**WELWYN HATFIELD BOROUGH COUNCIL
EXECUTIVE DIRECTOR - PLANNING, PUBLIC PROTECTION AND GOVERNANCE**

Application No: 6/2022/1651/LB
Location: Northaw House Coopers Lane Northaw Potters Bar EN6 4NG
Proposal: Re-construction of demolished Walled Garden lean to store
Officer: Mr William Myers

6/2022/1651/LB

NORTH ELEVATION

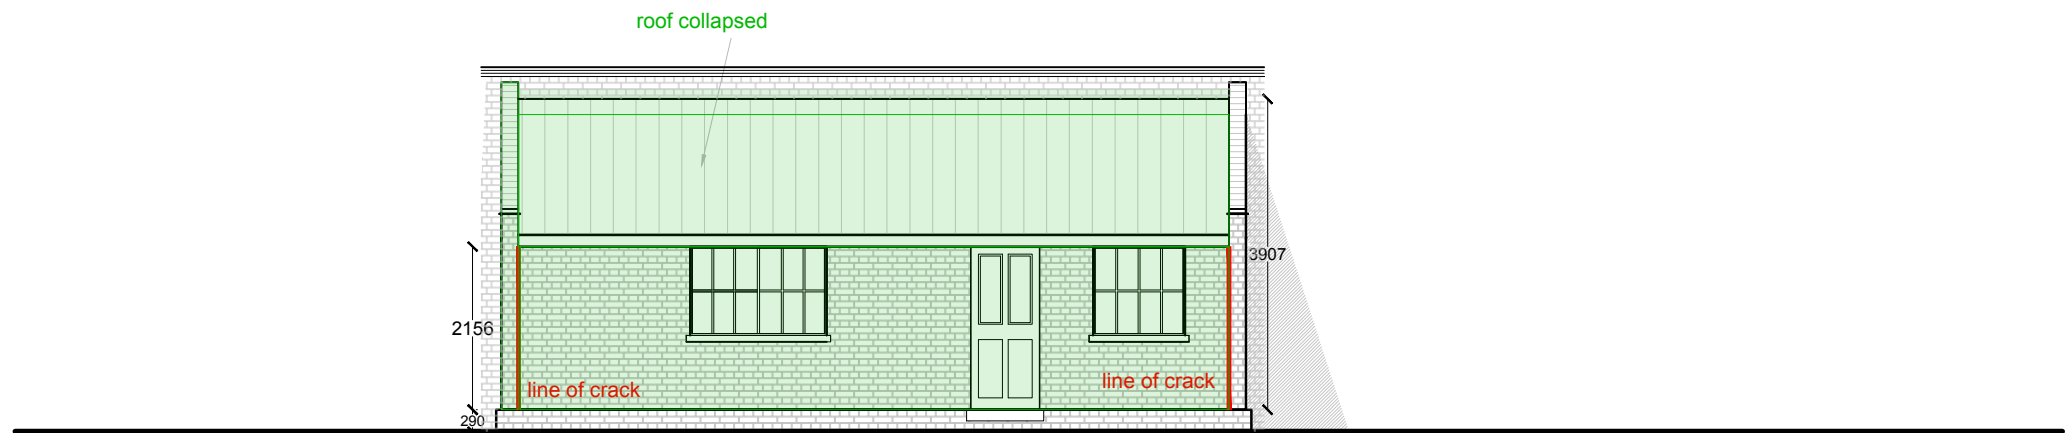
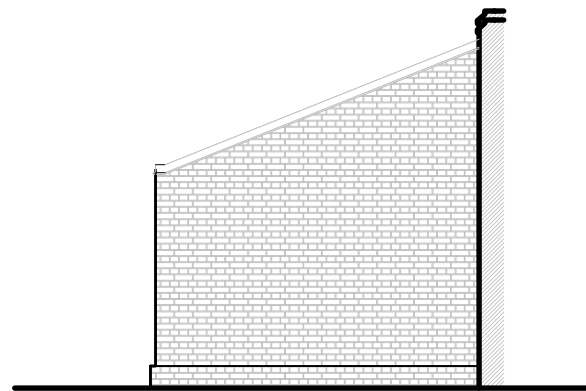
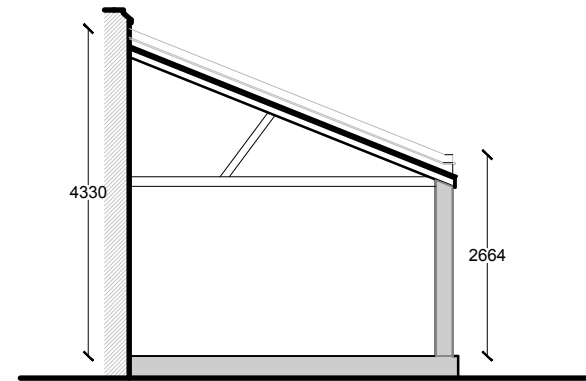
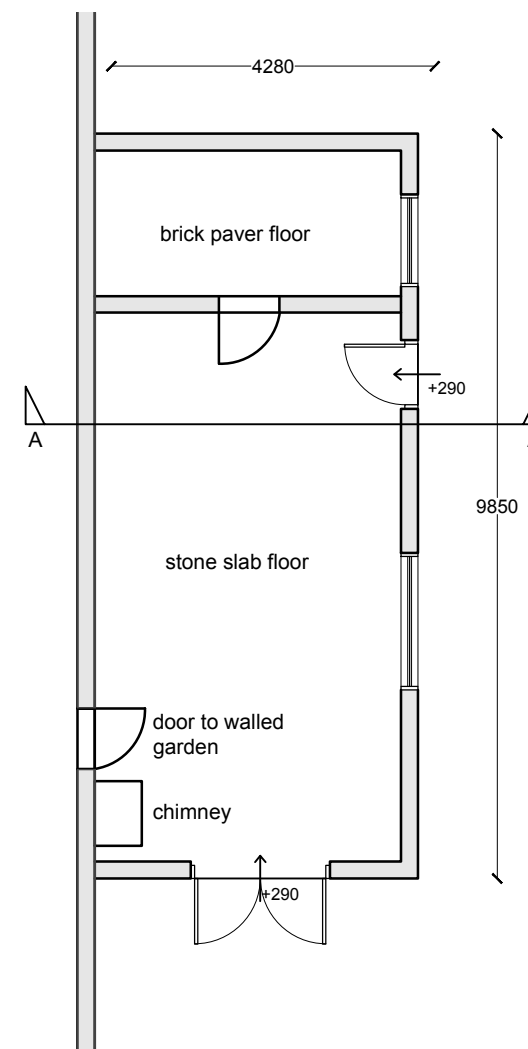
Following a request for revised drawings, it is now considered that the submitted drawings show the accurate reinstatement of the roof structure, doors, windows and internal flooring. Whilst it is noted that these plans do not include the pre-existing chimney and internal wall it has been agreed that these features do not need rebuilding.

It is also proposed to point the brickwork of the lean to structure to match the adjoining wall of the Walled Garden.

1. Detailed drawings of the new windows and doors in section and elevation, at an appropriate scale, must be submitted to and approved in writing by the Local Planning Authority prior to their first installation.

4. The new pointing must match the mortar colour and mix and pointing profile of the existing pointing of the adjoining garden wall, which is shown within the Details of Materials document submitted on the 5th December 2022, unless otherwise agreed in writing with the Local Planning Authority.

5. Any new rainwater goods must be black painted metal unless otherwise agreed in writing with the Local Planning Authority.
